CITY OF ALBUQUERQUE
PLANNING DEPARTMENT
DEVELOPMENT REVIEW BOARD

Project # 1005257

06DRB-01638 Major-SiteDev Plan BldPermit

DESIGN 2 FUNCTION LLC agent(s) for EEEEC, LLC request(s) the above action(s) for all or a portion of Lot(s) 3A1C, Block(s) A, **INTERSTATE INDUSTRIAL TRACT, UNIT 2**, zoned IP industrial park zone, located on GULTON CT NE, between OSUNA RD NE and NORTH DIVERSION CHANNEL containing approximately 1 acre(s). (E-17)

REFUSE ENCLOSURE DETAIL

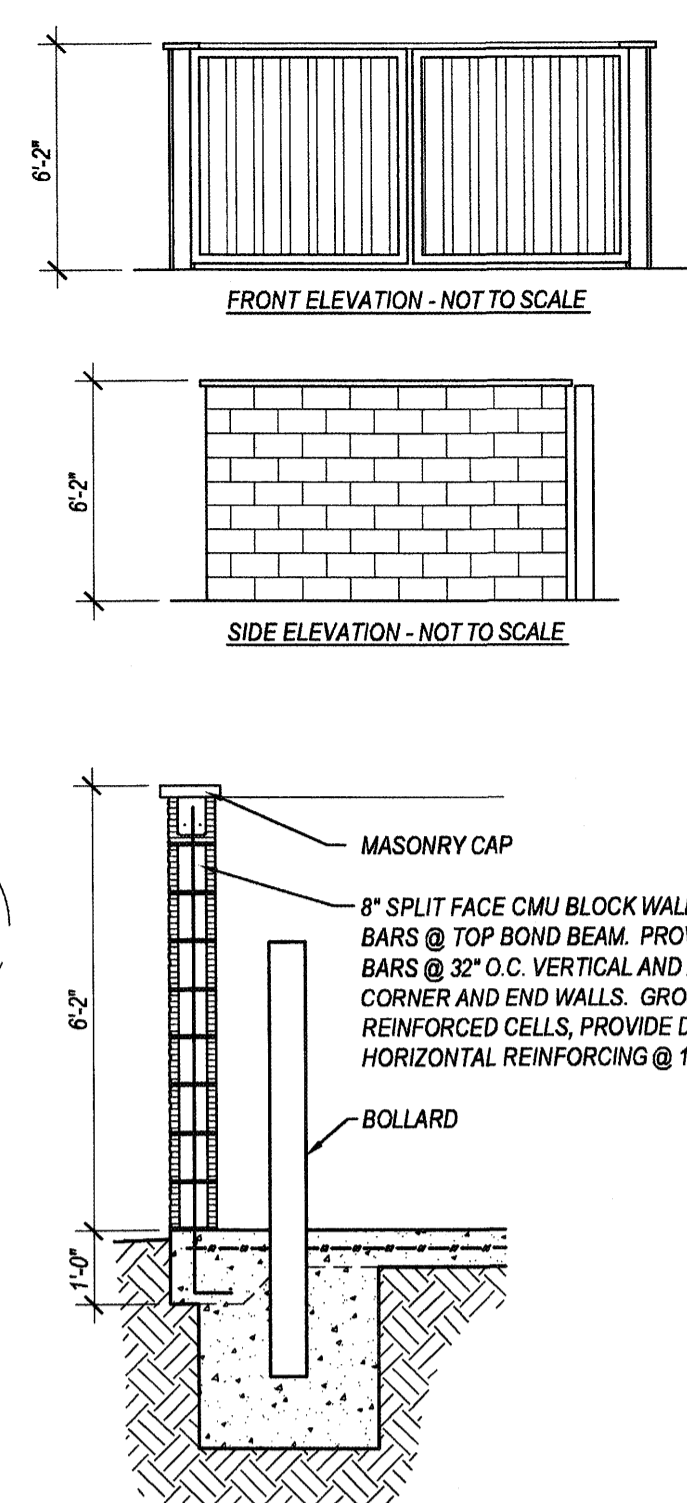
The refuse enclosure split face block needs color identification.

SITE PLAN

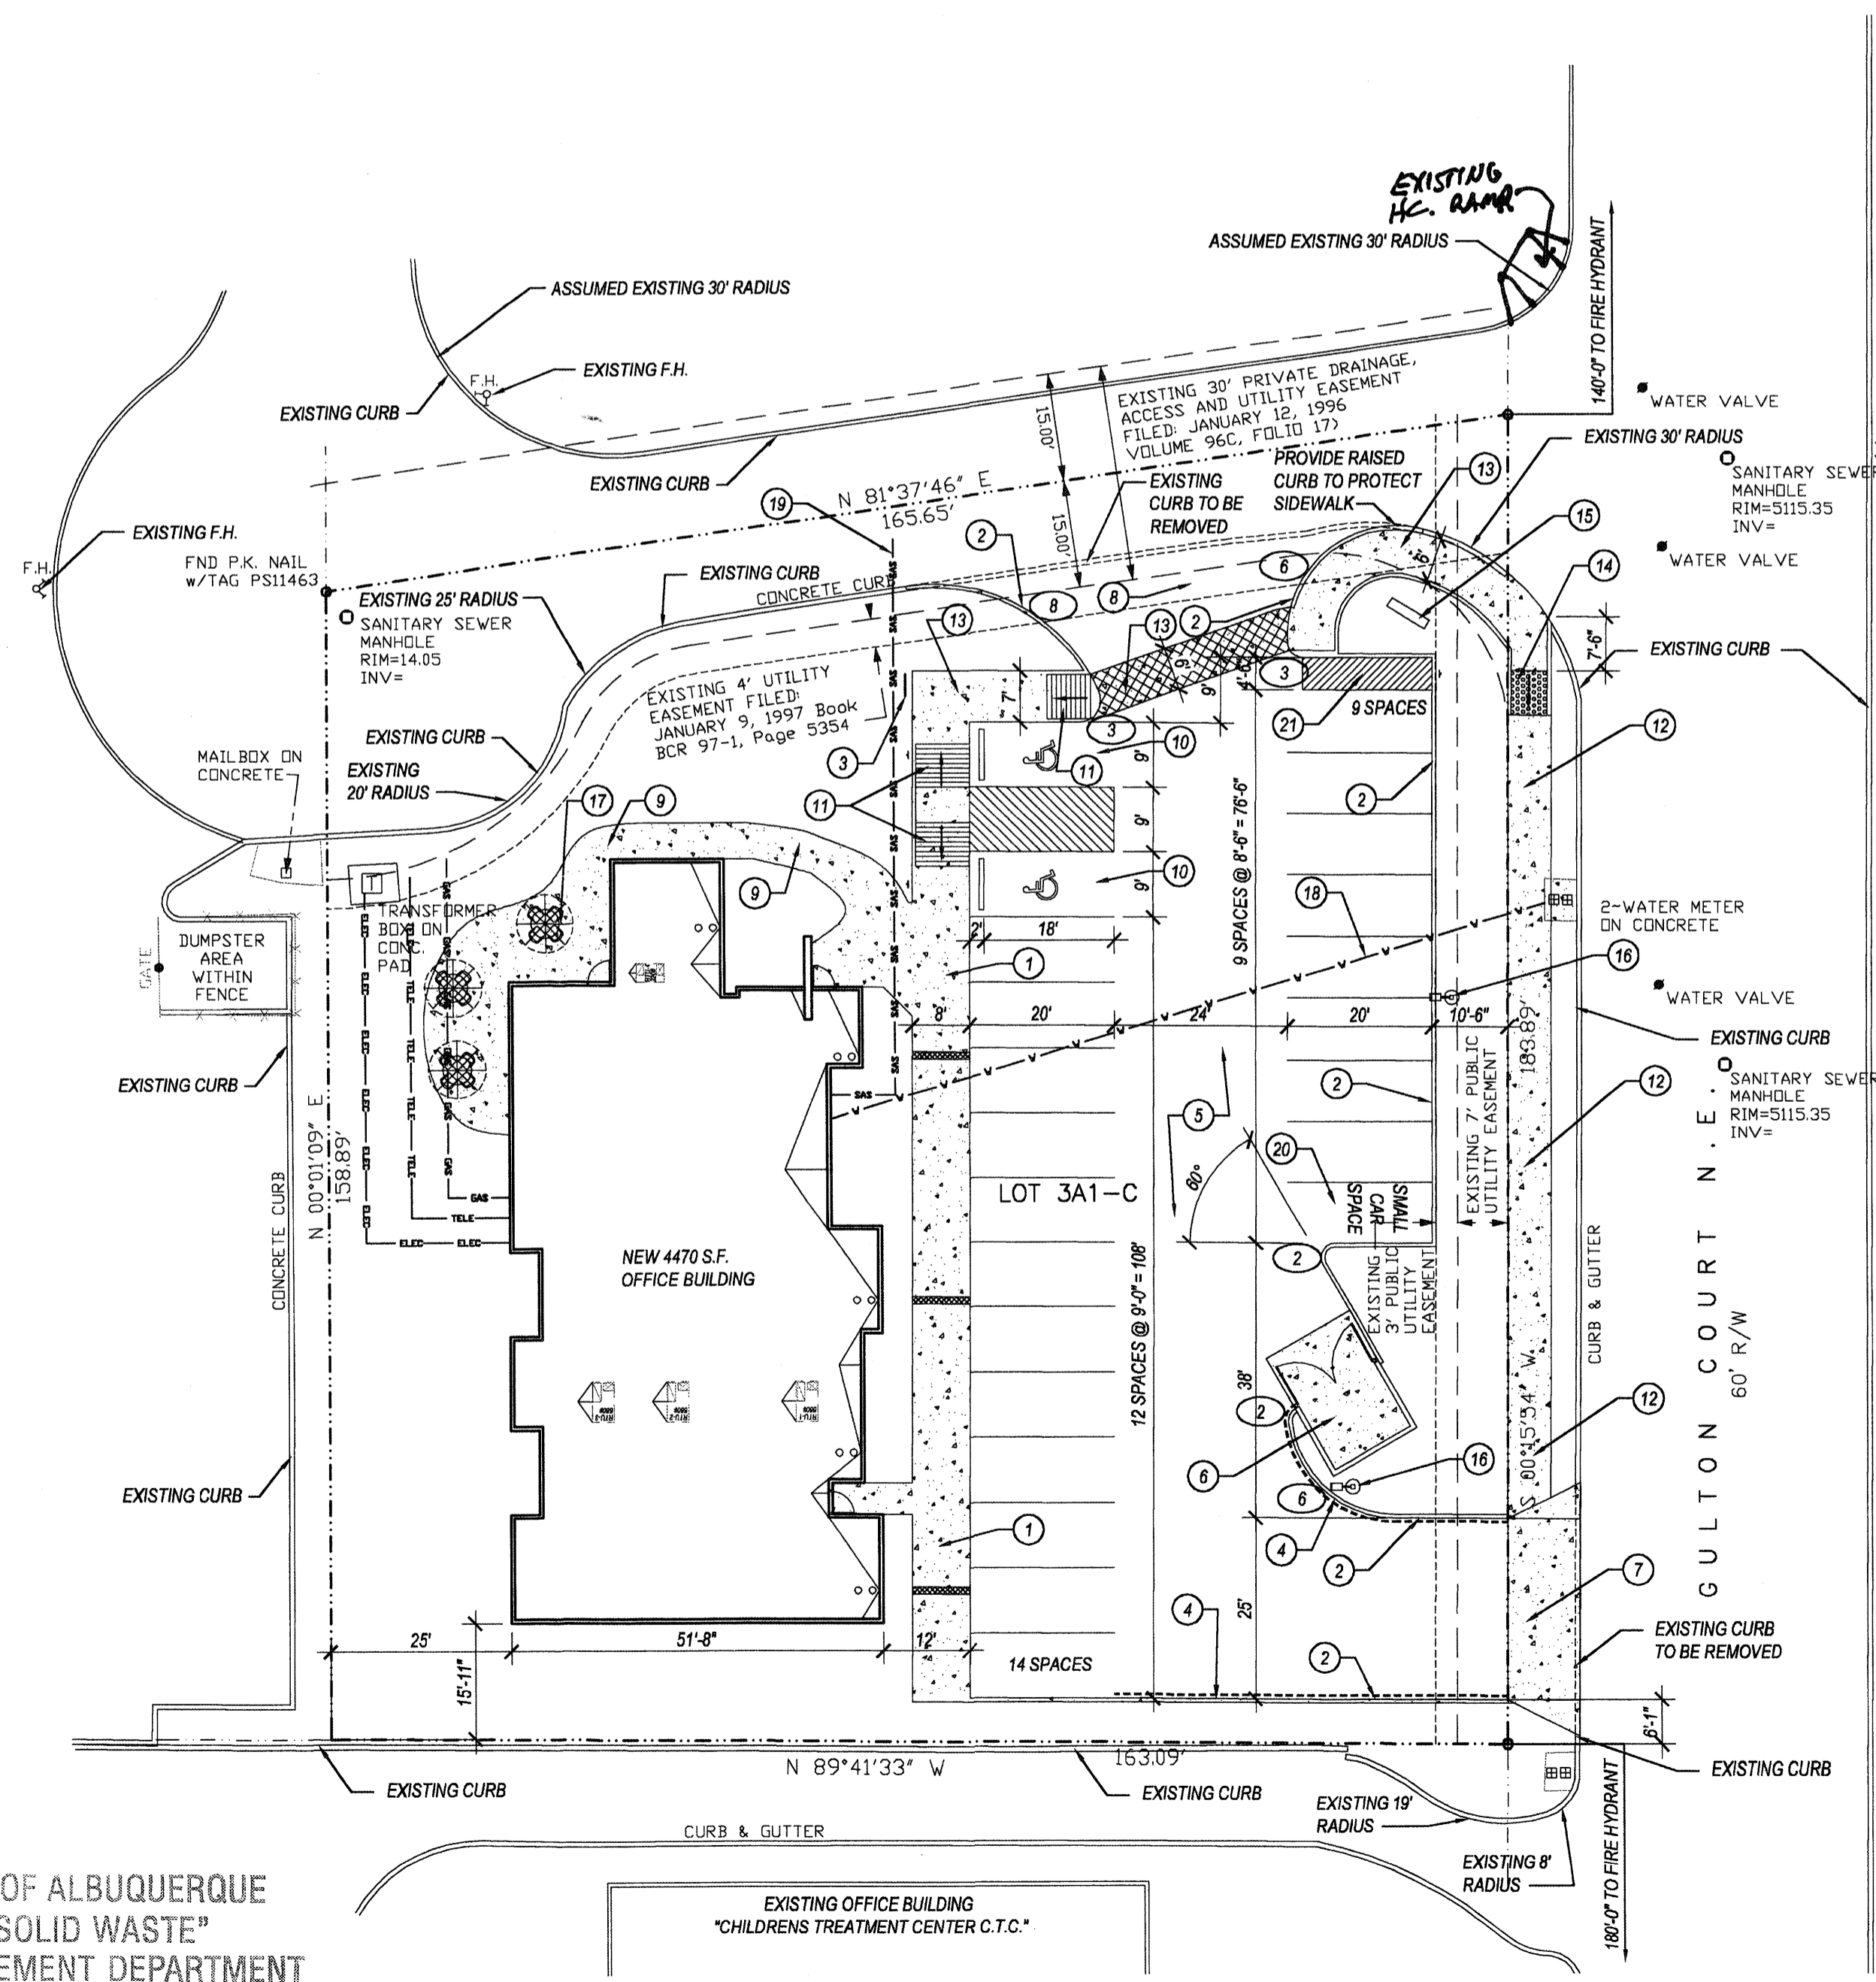
The site plan is missing the Conceptual Utility Plan sheet. Planning and Utility Development need copies of this sheet.

The title on the site plan sheet should read "Site Plan for Building Permit".

Keyed Note 15 on the site plan indicates a monument sign. However, Planning did not find a 15 on the site plan. We assume it is located at the corner of GULton Court & Osuna.

Where is the wall, fence or screening? The checklist indicates it exists. If it does, a Keyed Note is needed. The refuse enclosure does not count in this instance.

The patio area on the north & west sides of the building need tables and benches for employees and shade.

The site lighting item was checked on the checklist. Is there free standing lighting? If so, locations and an elevation are needed with height & fixture type.

It appears there is an existing structure to the south of this site within 20 feet of the site. It needs identification on the site plan.

Lighting on the building. The west side does not appear to have lighting?? Will building mounted lighting be sufficient to light the parking lot at night for security reasons?

The monument sign details required on the checklist must be on the site plan. If changes are needed later, an AA can be done. Remember to provide revised site plan to Planning by noon on Monday plus the photographs referred to earlier.

Sheet Title:
Landscape Plan

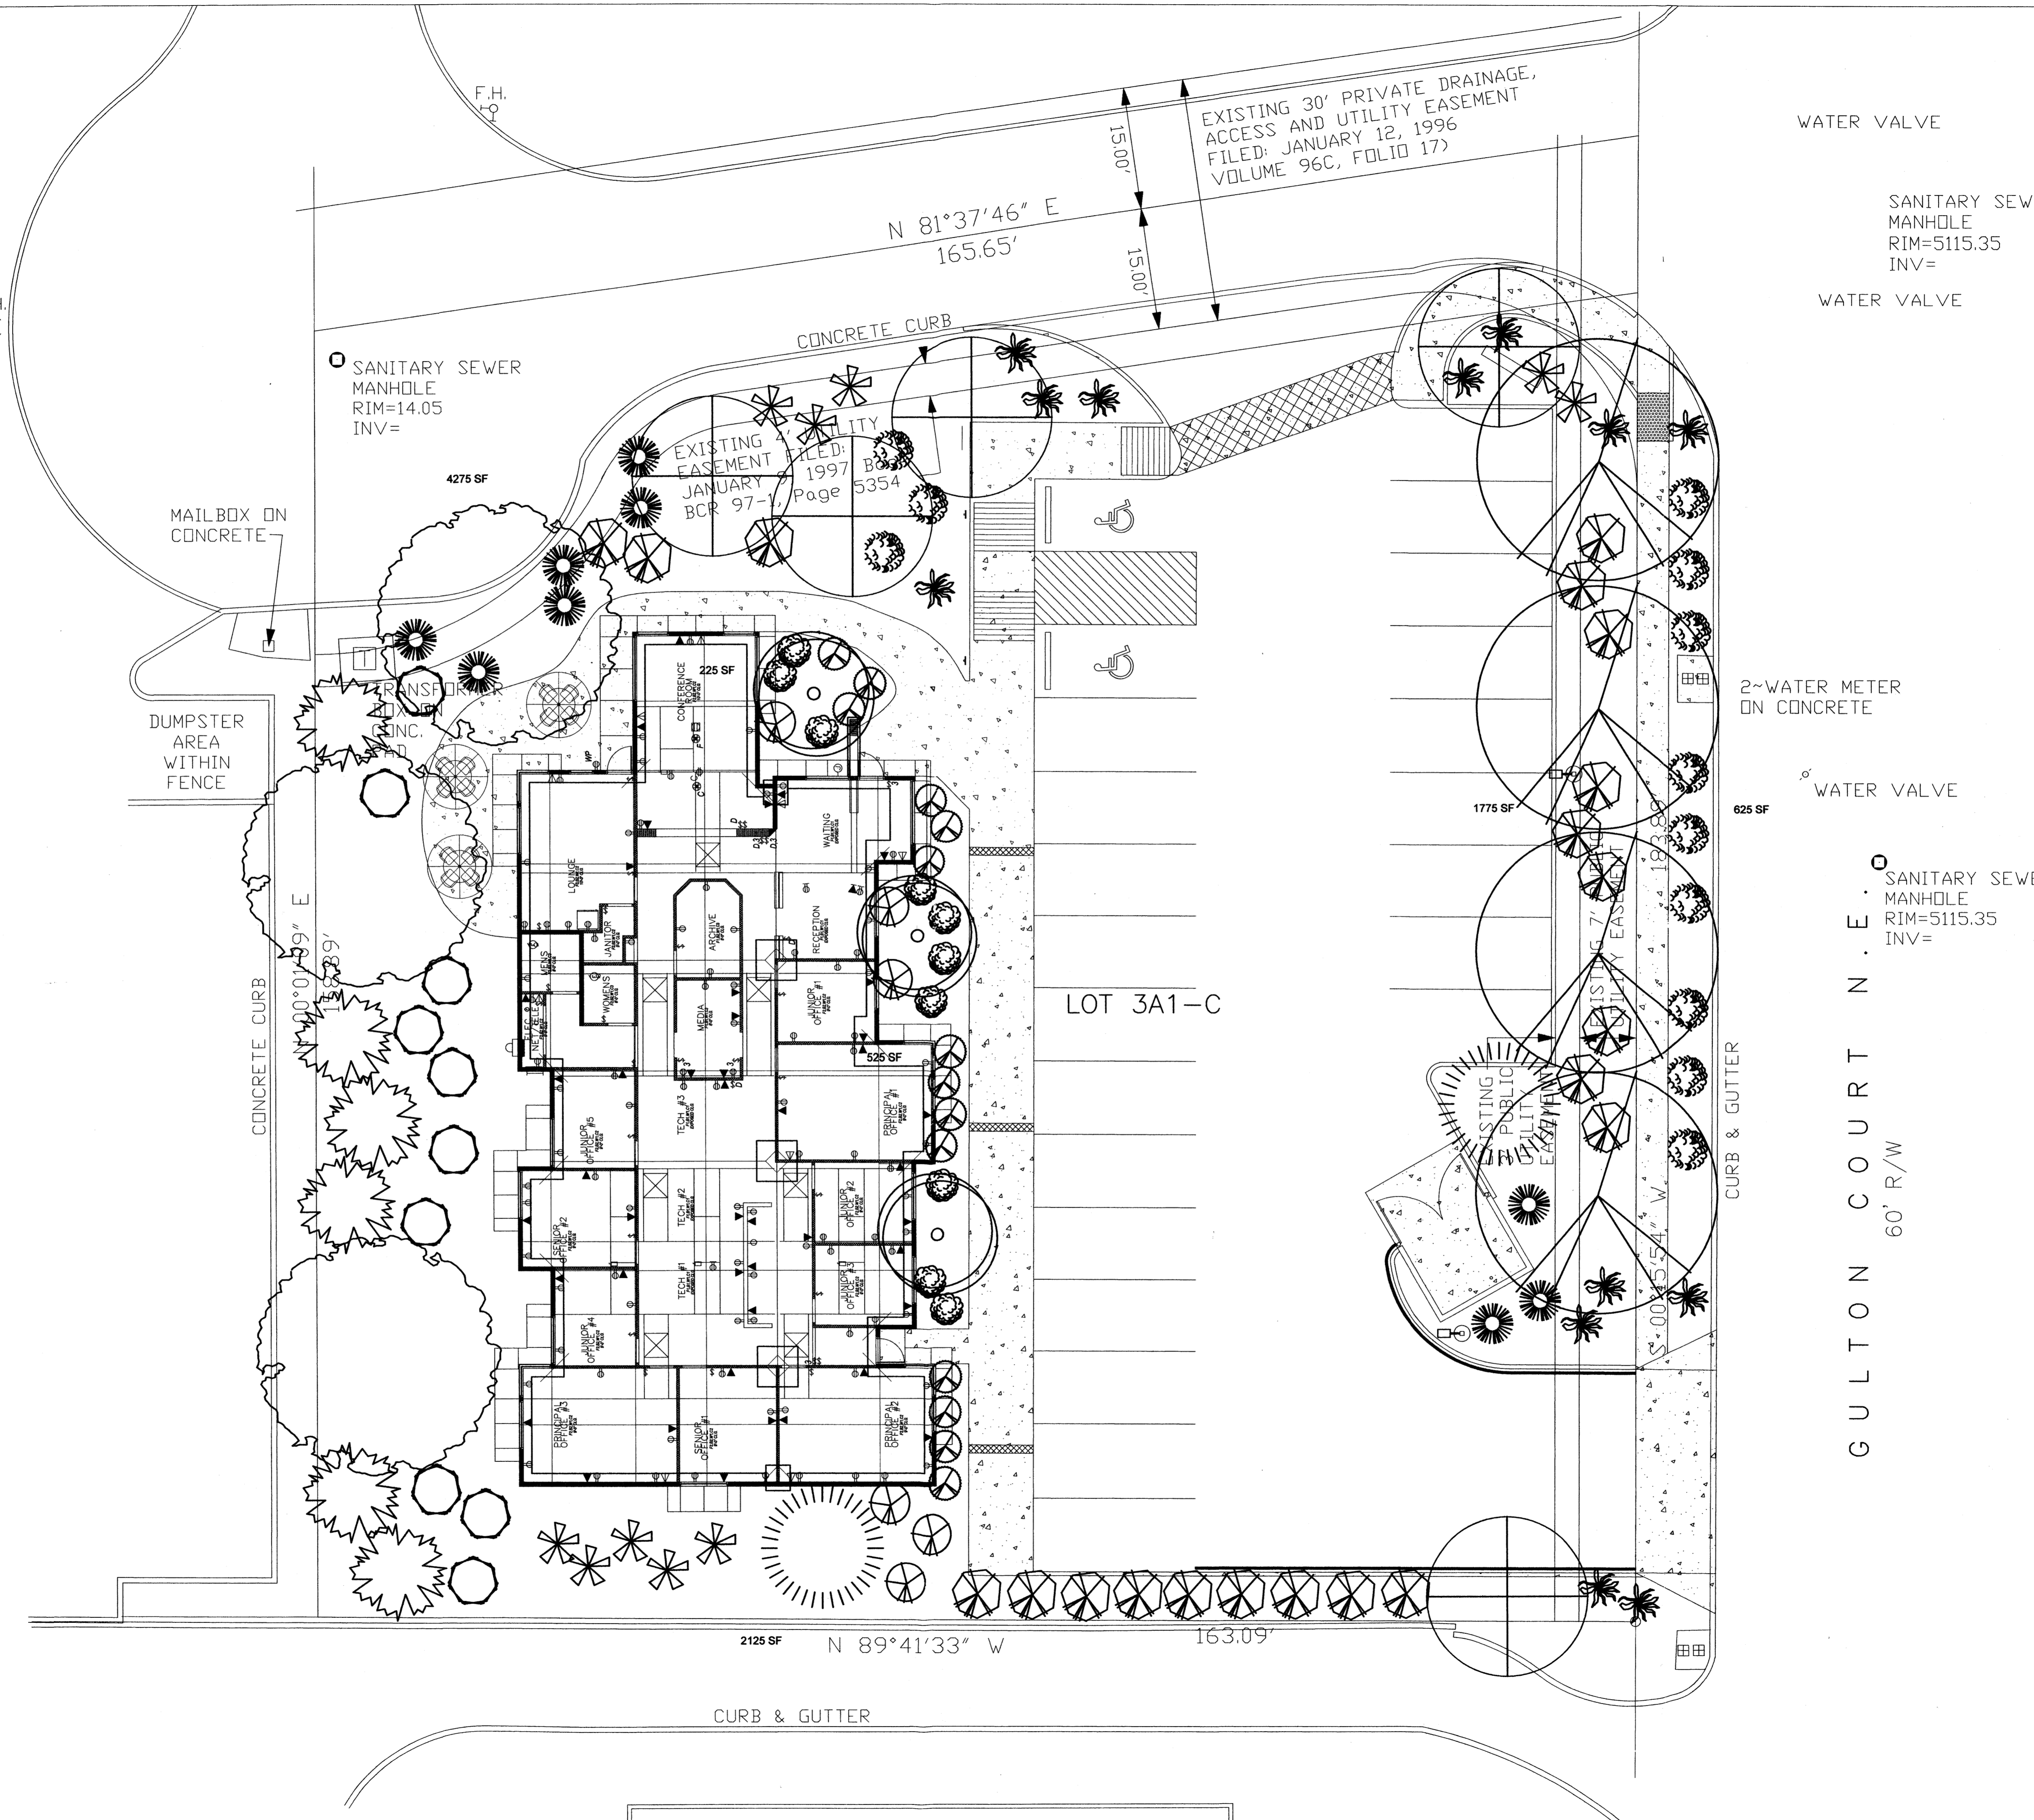
1. Easements must be identified on this sheet.
2. No junipers are allowed. Please remove & provide a substitution.
3. Indicate on this sheet where the tables & benches will be on the patio.
4. Because the parking lot is adjacent to Gulton Court, a greater effort to shield the parking area from the street should be made through the use of tall, dense shrubbery or shifting some of the taller plants to this area. The area just east of the turnaround is bare of plants.
5. The specific gravel mulch used must be identified and a minimum of 3" depth is required.
6. In the future, the landscape plan and site plan must be the same scale.
